WEST SUSSEX COUNTY COUNCIL (Page 1 of 1)

TO:	Arun District Council FAO: Michael Eastham
FROM:	WSCC Highway Authority - Matthew Bartle
DATE:	7 August 2019
LOCATION:	Blakes Mead Felpham PO22 8FW
SUBJECT:	FP/37/19/DOC Approval of details following outline planning permission FP/92/04 for Phases 4 & 5 of residential development relating to Conditon Nos 17, 18 and 25.
RECOMMENDATION:	Advice

B	03/06/18	Amended to suit WSCC comments.	HJS
A	06.05.14	Plot numbers updated.	HJS
REV. No.	DATE	DESCRIPTION	INITIALS
Client			
Project	Phase 5A, B & C Bognor Regis		
Title	Section 38 Layout Sheet 2 of 2		
Scale	1:500@A1	Date	Nov'12
Checked		Drawn	JK
Drawing No.	4348:501	Rev	B

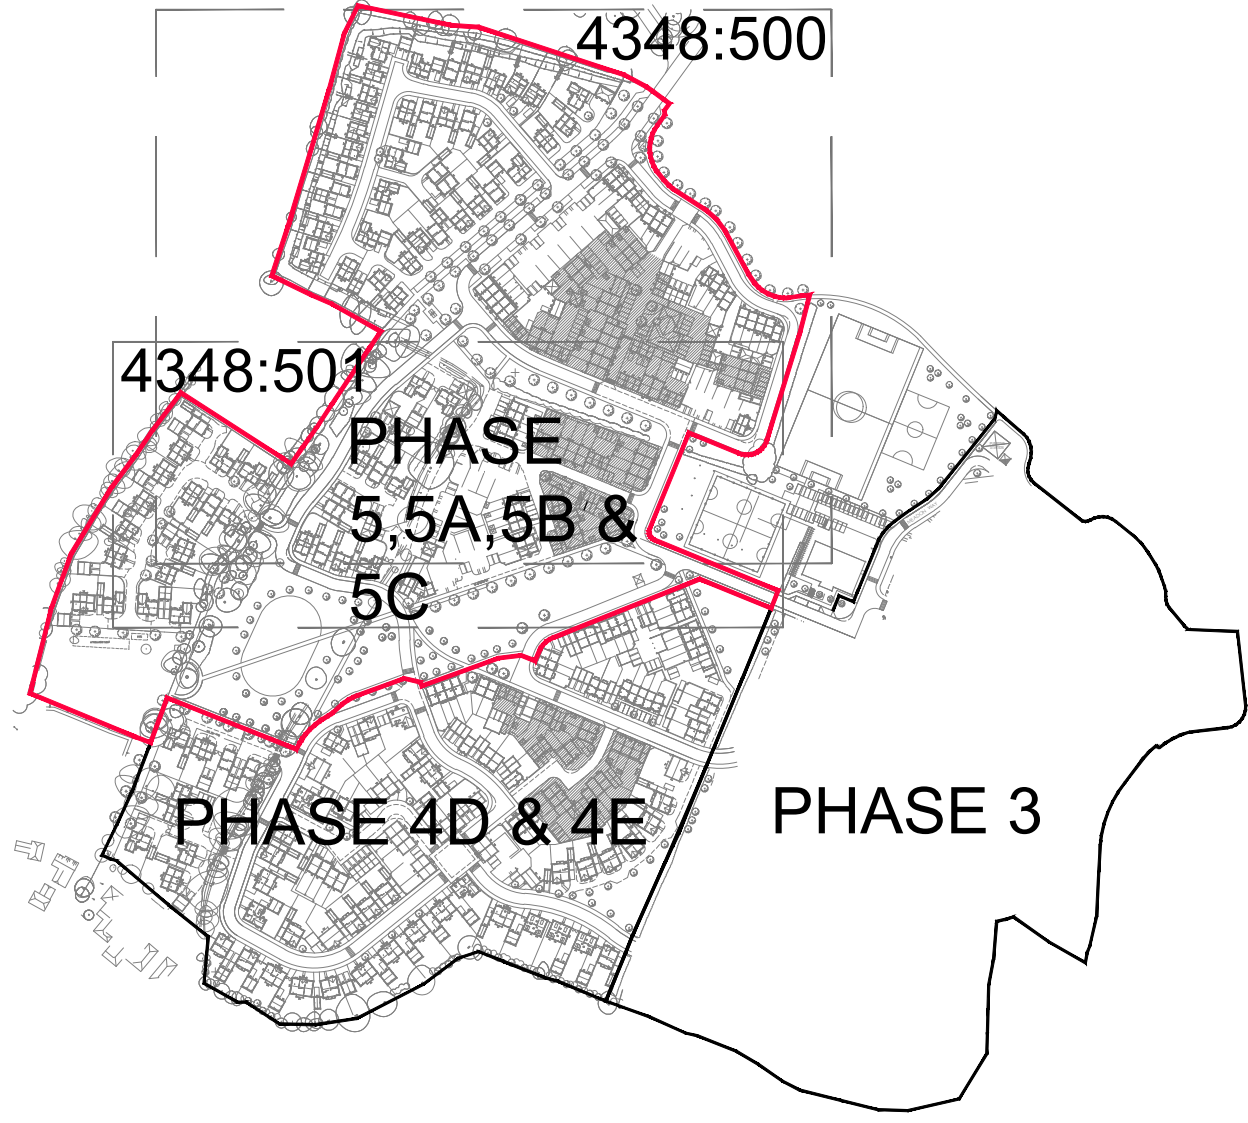
Following examination of drawings 4348: 07, 500B, 501B, 5000A the highway authority considers that vehicle tracking drawings for the site should be provided, based on a drawing for the whole site.
